MOUNTAIN SPLENDOR SERVICES, INC.
EL PASO COUNTY, STATE OF COLORADO
SITE DEVELOPMENT PLAN

SITE
DEVELOPMENT
PLAN

BUILDING
ELEVATIONS

1 EXISTING OFFICE / RESIDENCE - EAST ELEVATION
NOT TO SCALE

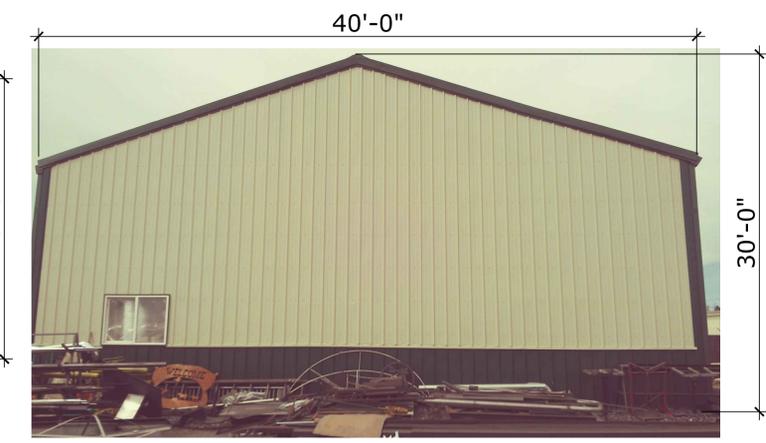
Please provide the height of all buildings on the elevations plans. a statement of not exceeding 30' is not sufficient for a site development plan.
